Demolish 1 house (60 Sea Lane); partially demolish 1 house (45 The Ridings); construct 3 detached houses; alterations and extensions (45 The Ridings)
45 The Ridings and 60-62 Sea Lane East Preston

Thank you for your internet representation made on 22nd May 2013 which has been recorded as '**an objection**' with the comments as follows:

These comments are made on behalf of the East Preston and Kingston Preservation Society.

FLOOR PLANS & ELEVATIONS
UNIT 2

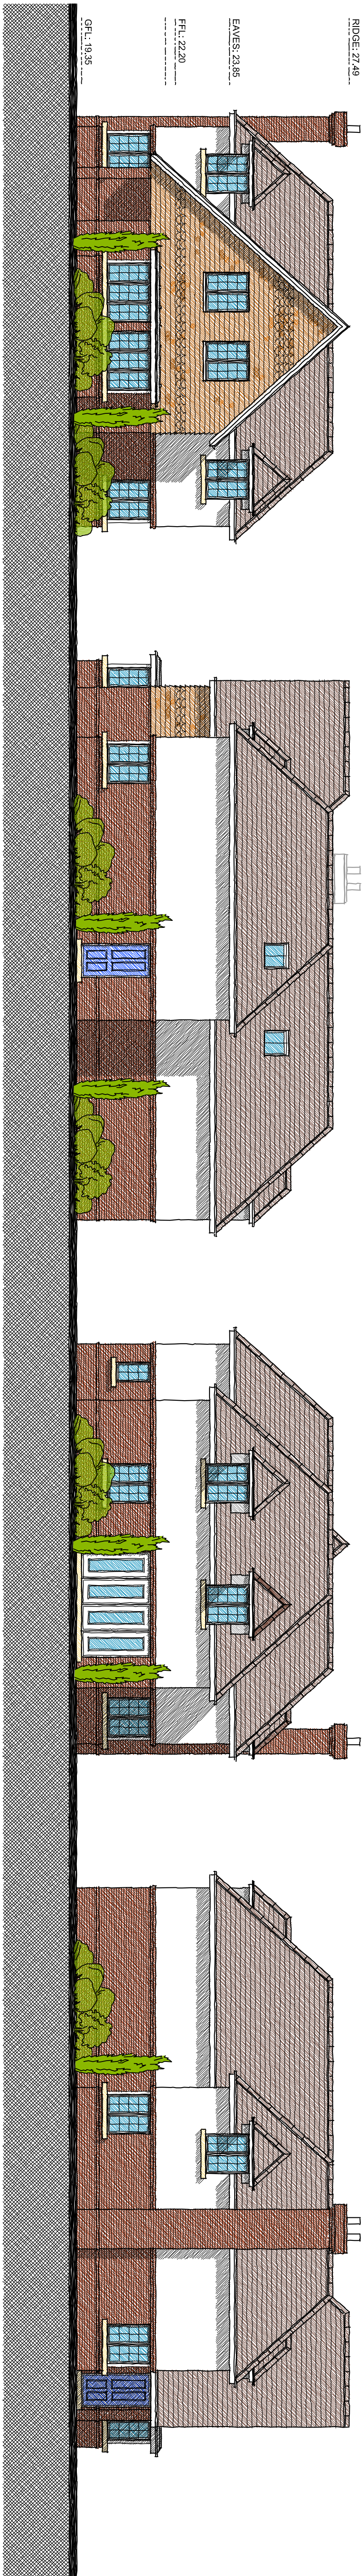
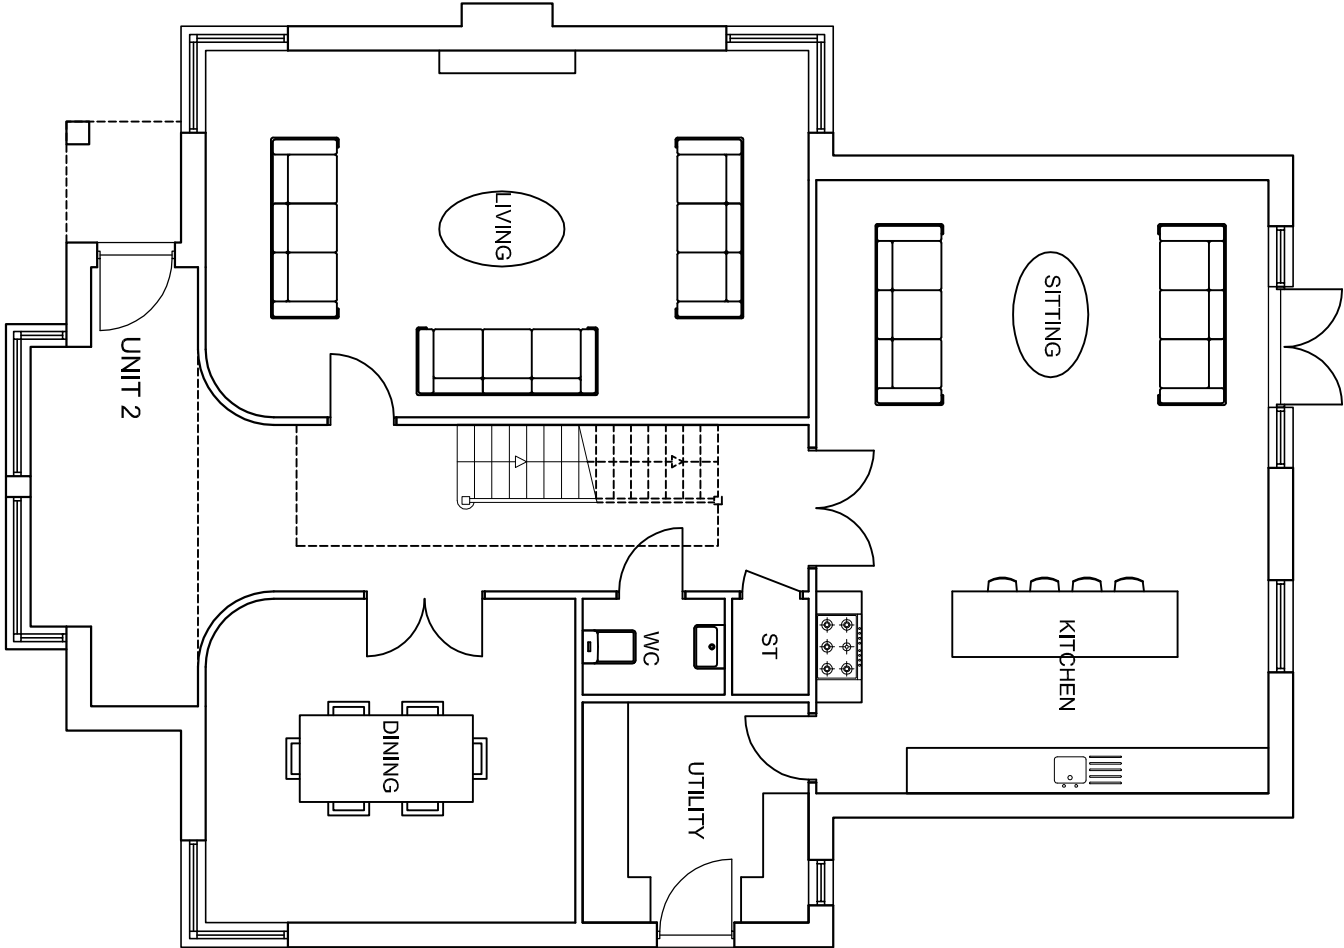
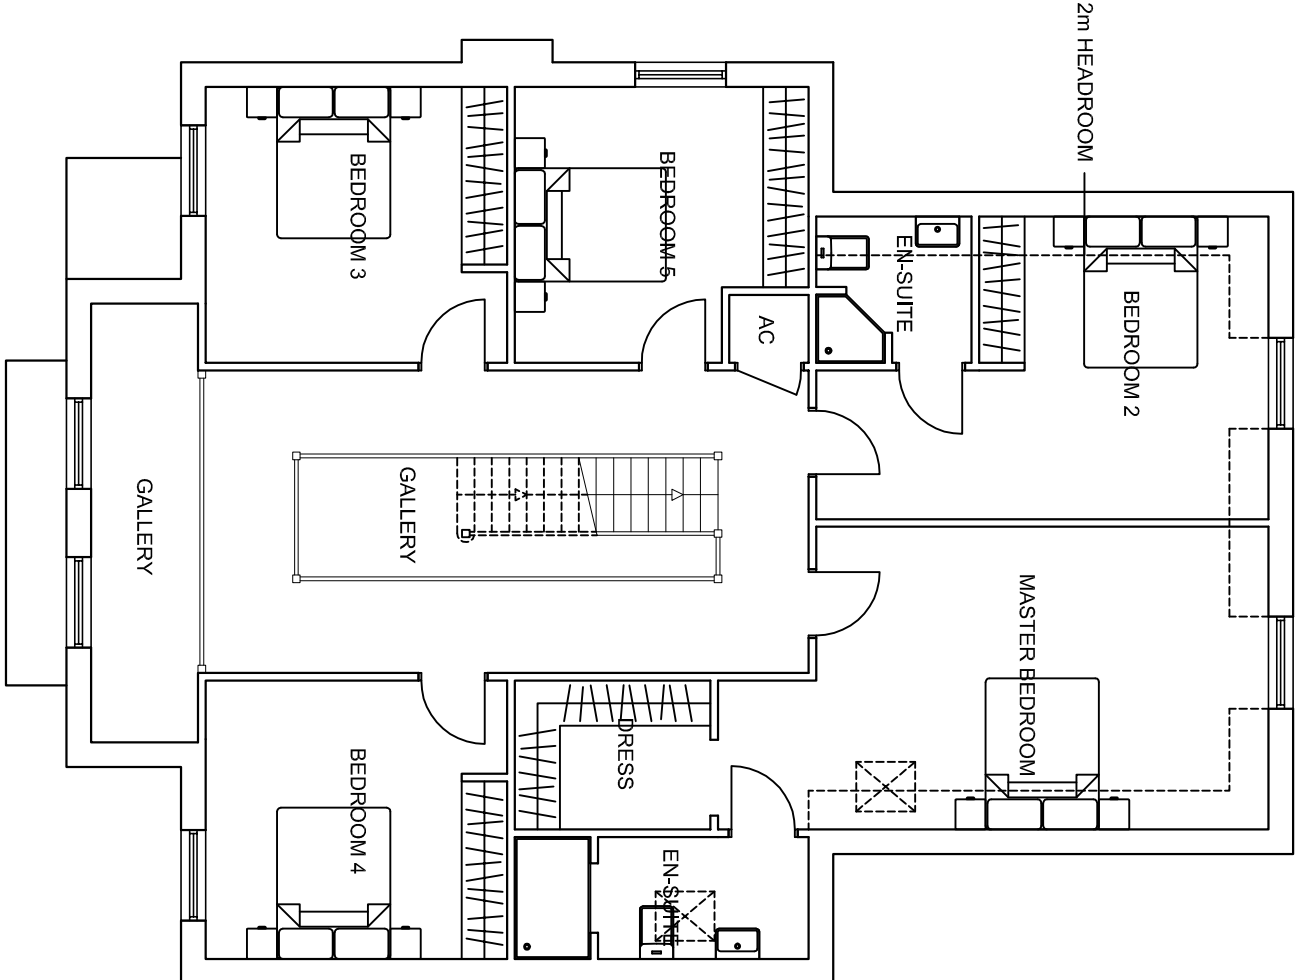
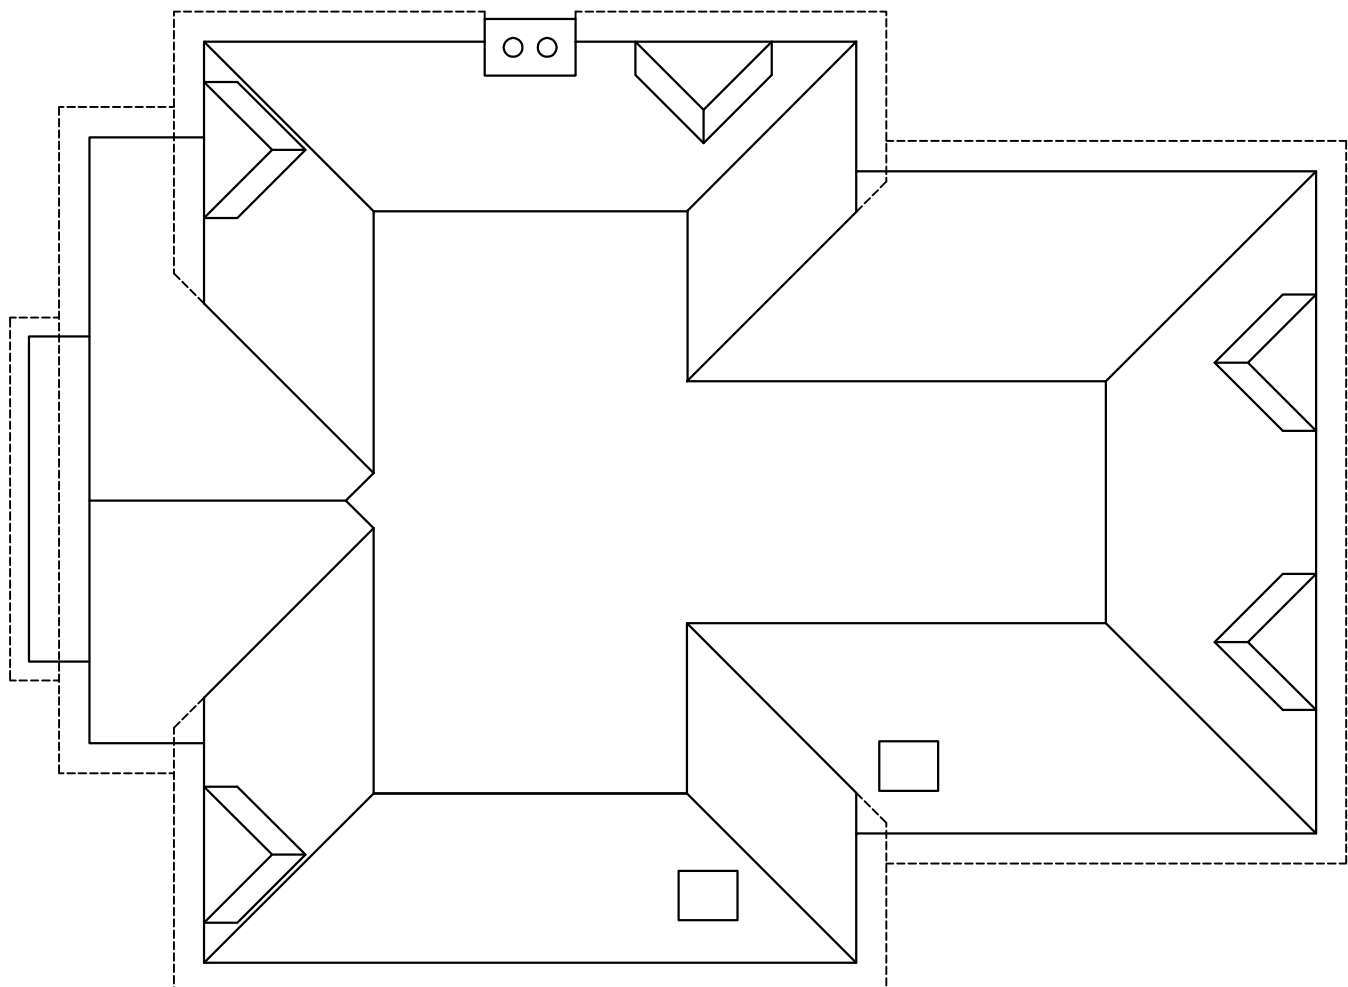
1. Height. The new houses would be significantly higher than neighbouring houses. The East Preston Village Design Statement says that new houses should not be significantly higher than existing buildings in a road. The height of the proposed houses should therefore be reduced.

2. The provision for car parking is inadequate, especially in units 2 and 3. The occupants of a five bedroomed house might have three cars; one single garage is not adequate.

3. The proposed materials are unsuitable for the location. Slate effect tiles and clay effect tiles should be replaced by real clay tiles for both the roof and the tile hanging on the walls, or the tile hanging could be replaced by rendering. The East Preston Village Design Statement says that the materials used in new buildings should harmonise in colour and texture with those used in existing buildings in a road.
